CITY OF ALBUQUERQUE

Re: Oxbow Development / Coors Pavilion Traffic Impact Study, draft
Engineer's Stamp dated February 9, 2022 (G11D067)
Received 2/10/2022
CABQ Planning Transportation comments

The subject Traffic Impact Study for the Oxbow Development / Coors Pavilion Traffic Impact Study dated February 9, 2022 has been reviewed by the City's Planning Transportation Development Section. The following should be addressed in the next submittal.

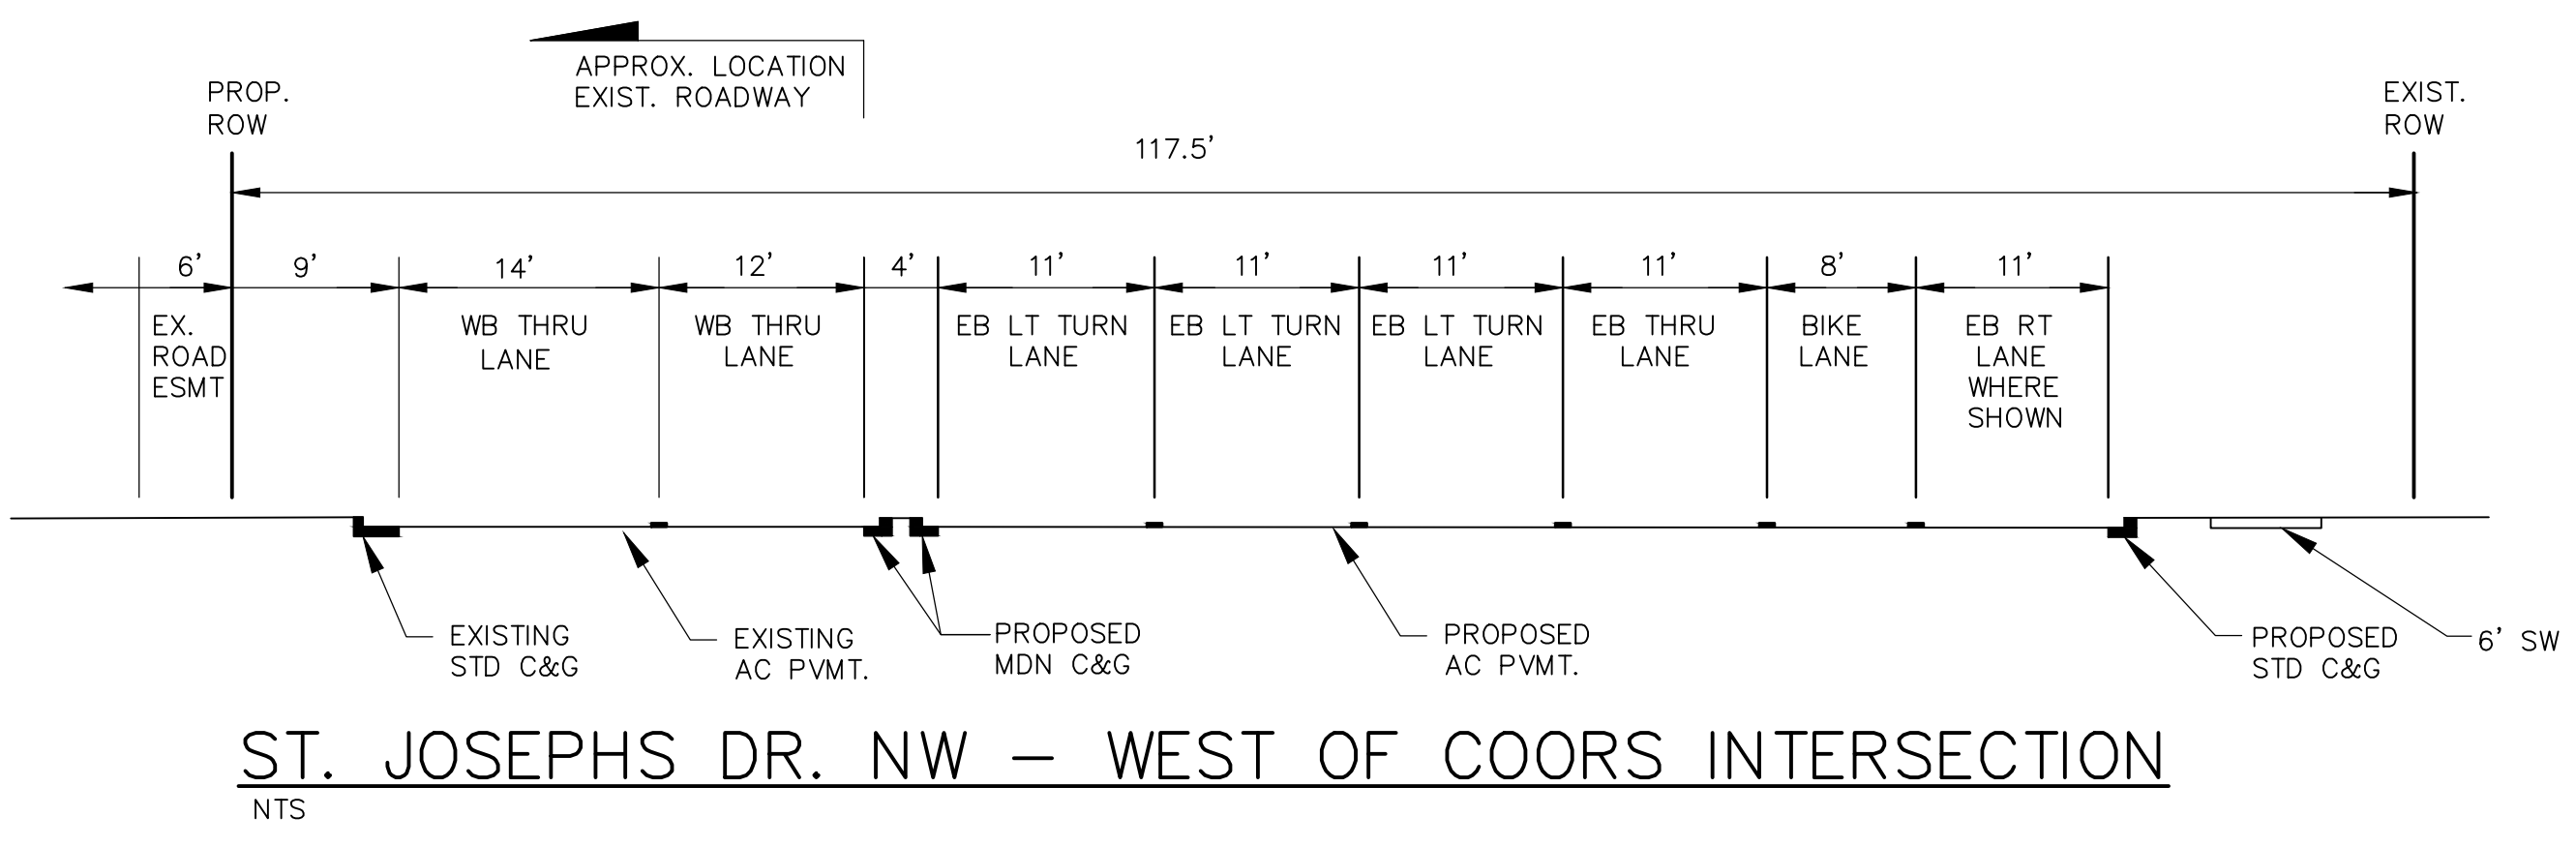
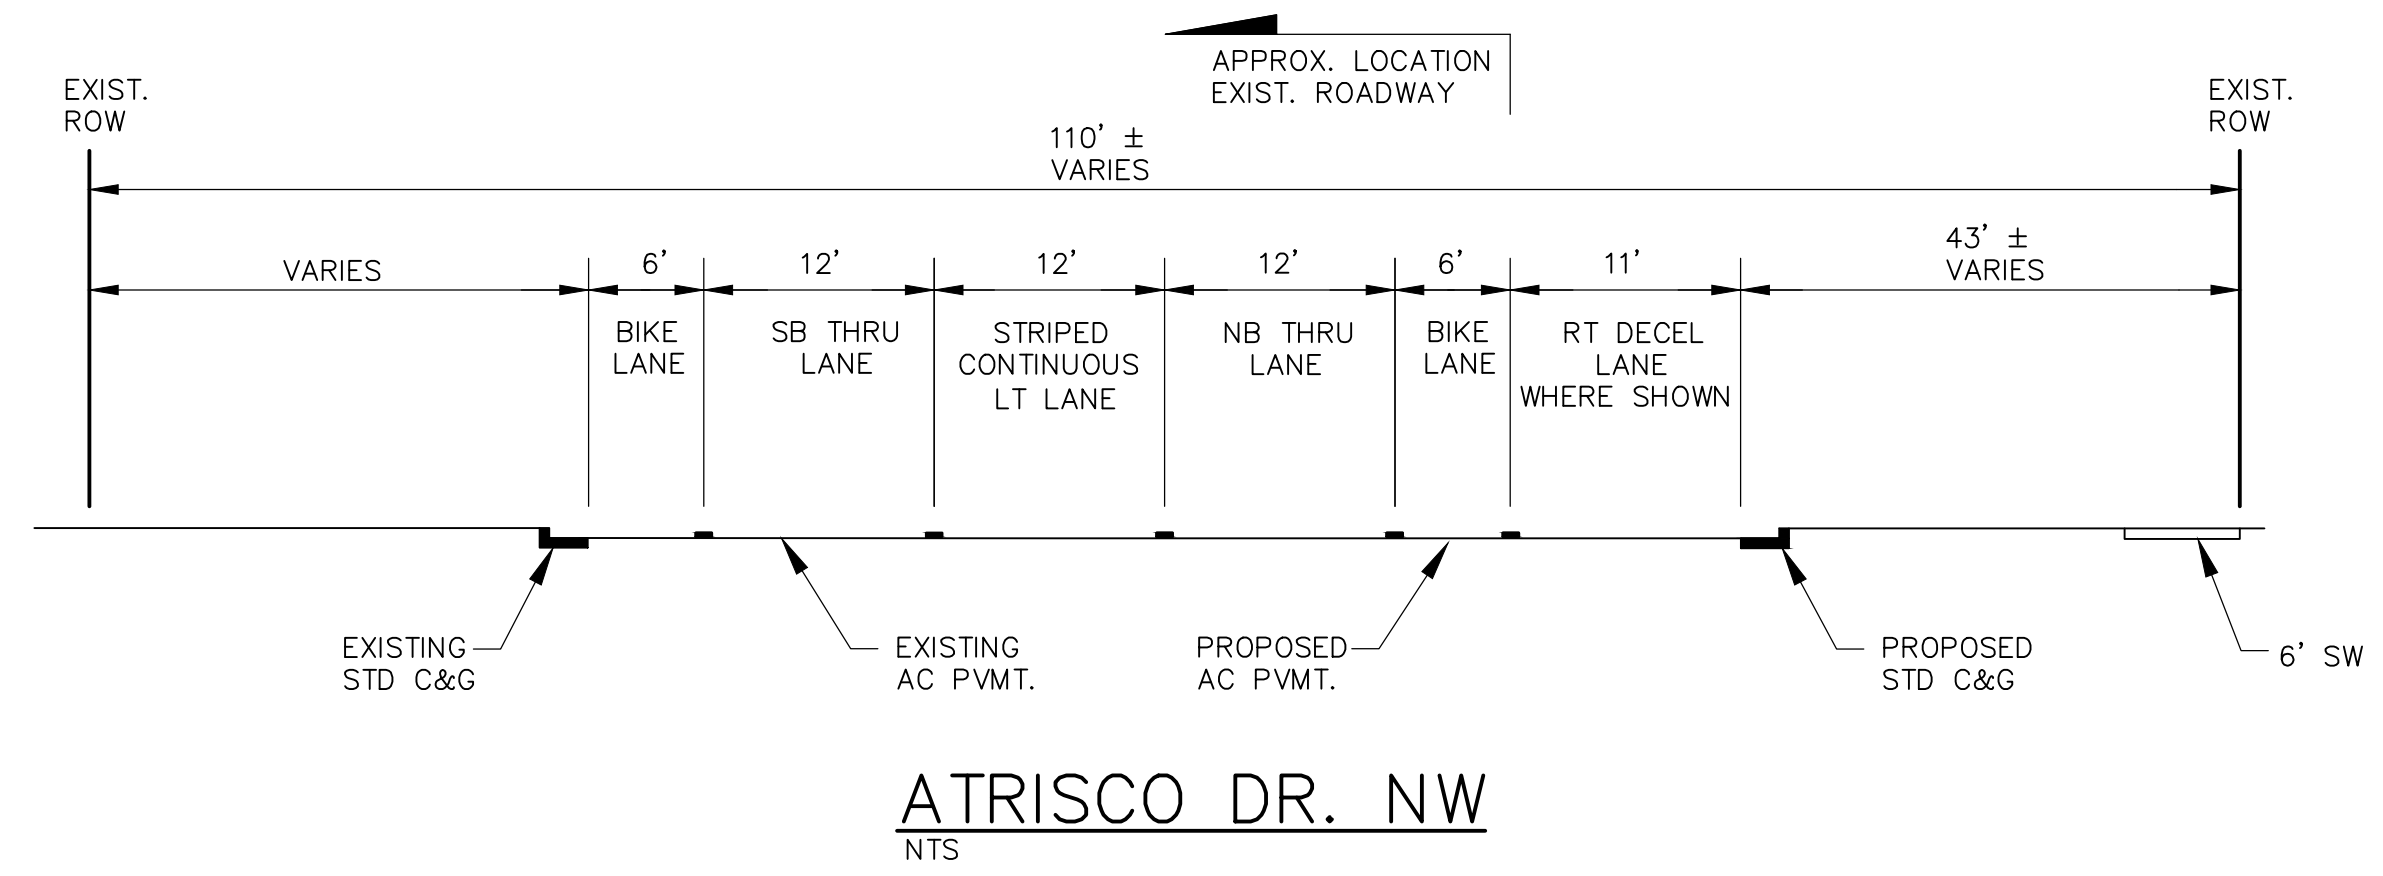
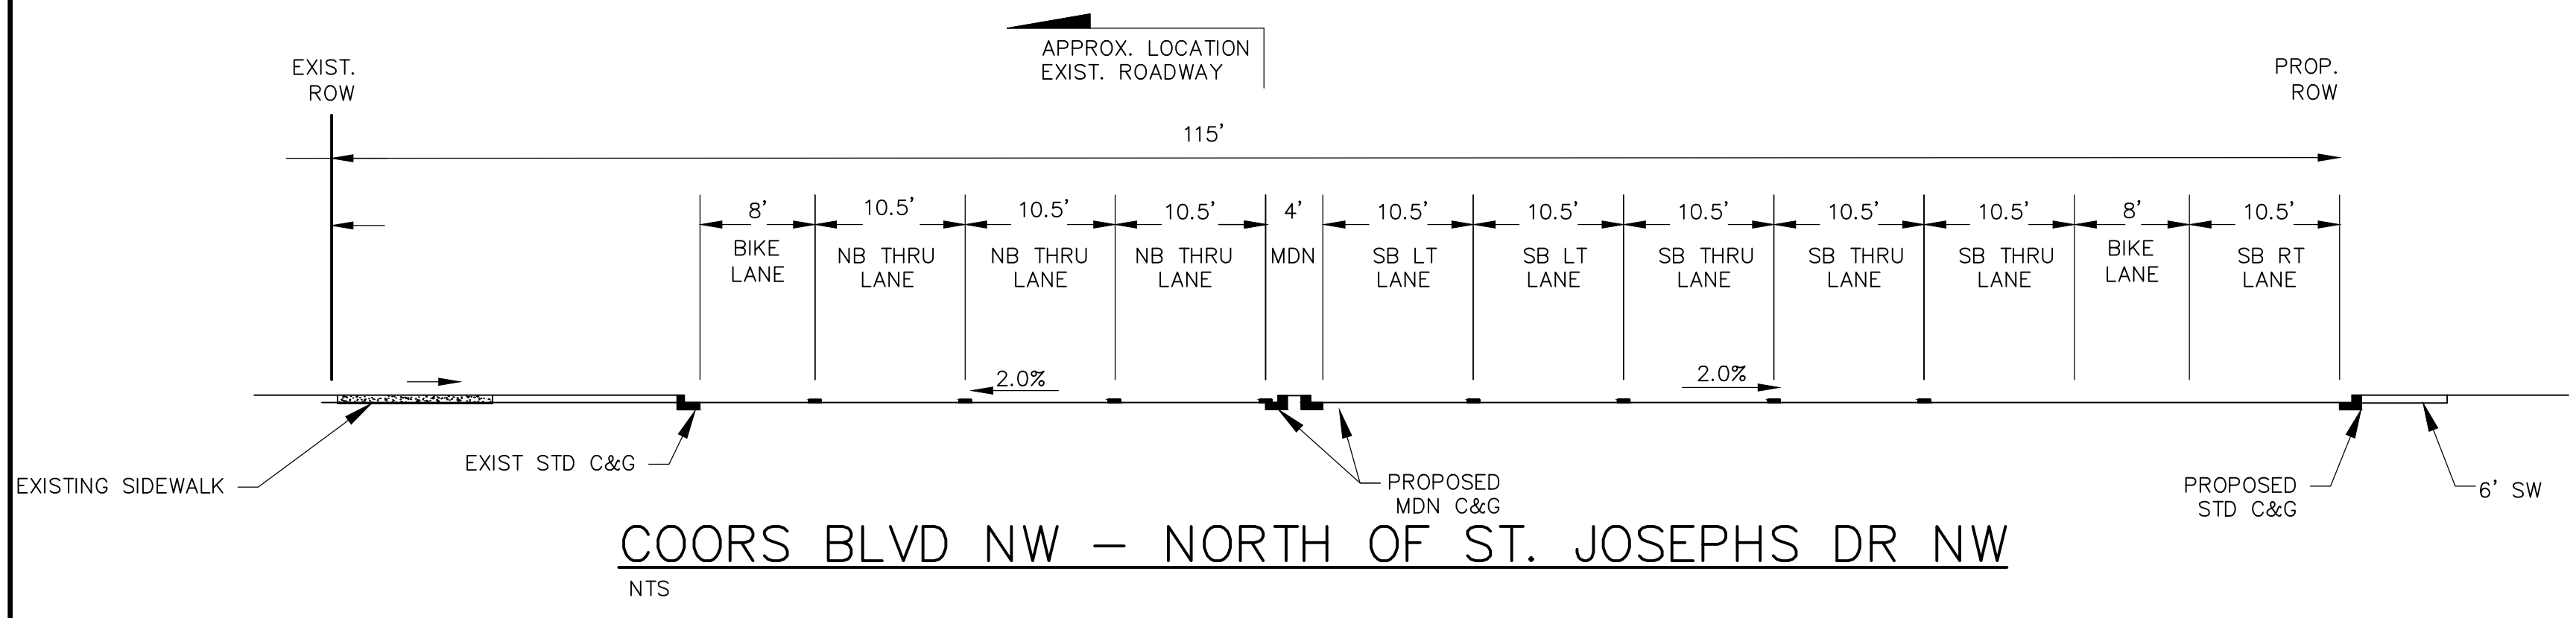
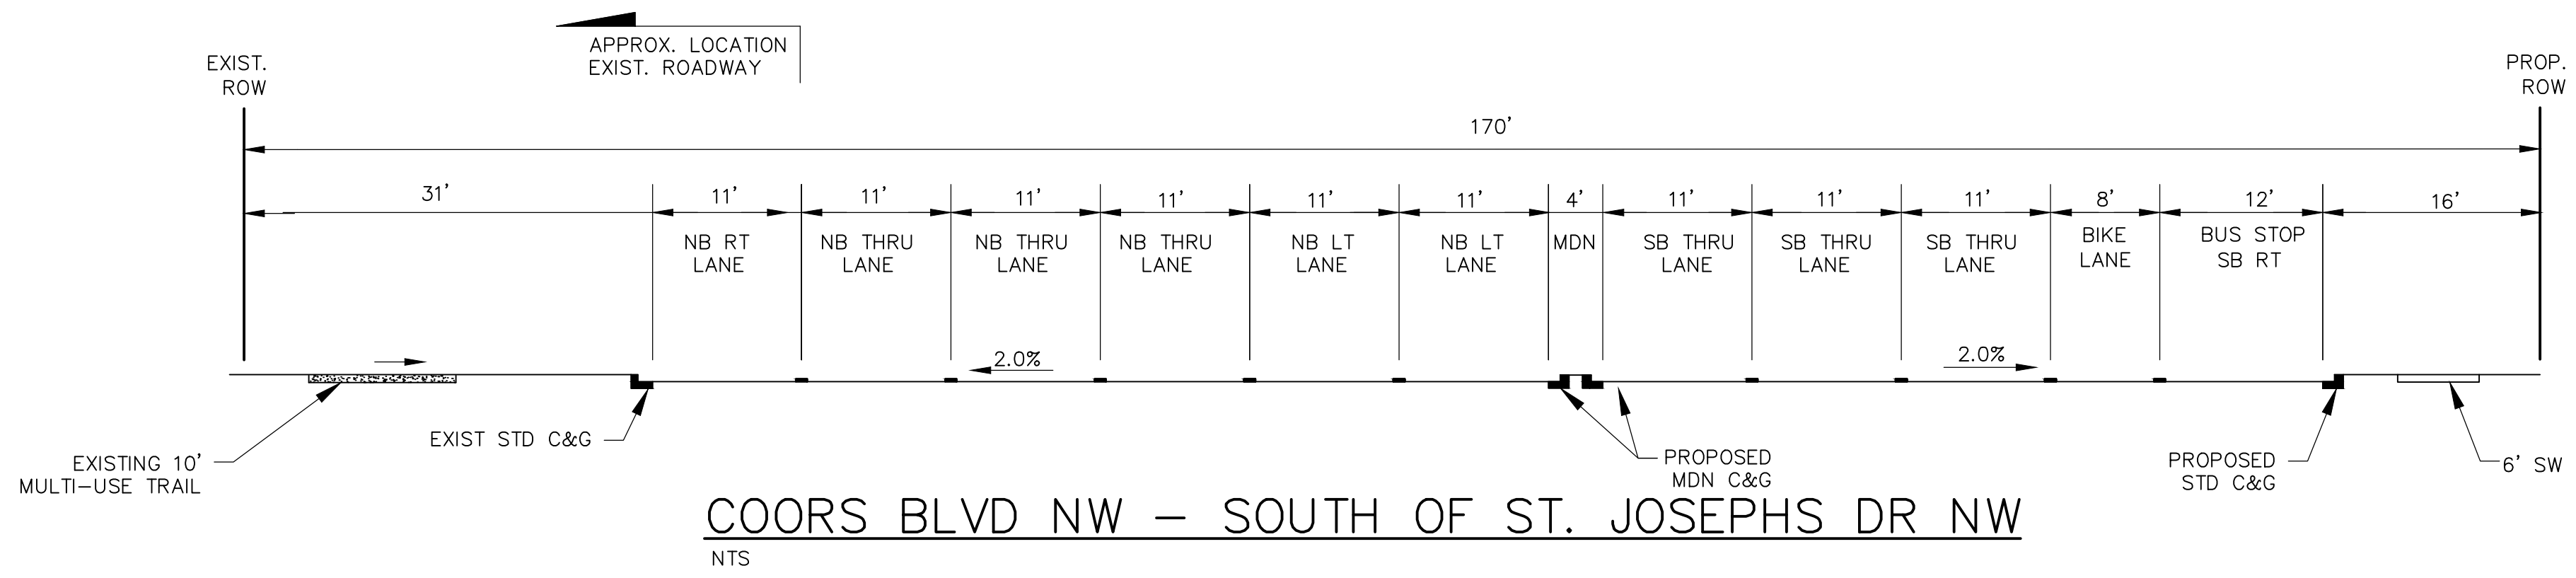
- Add eastbound bicycle lane with buffer to the crosssection.

- Provide a conceptual footprint of the main entrance to show that it will fit in the existing ROW. Add the eastbound bicycle lane with buffer.
- The traffic signal will need to be warranted. The traffic signal spacing is typically 1/4 to 1/2 mile. Inside an Activity Center the spacing may be reduced. Check the worst-case queuing at this intersection, and the approaches on St. Joseph's at Atrisco and Coors.
- Describe the queue length in feet. In some cases, the QRS is > 1. Explain how these queues will impact the Main Entrance Traffic signal operation.
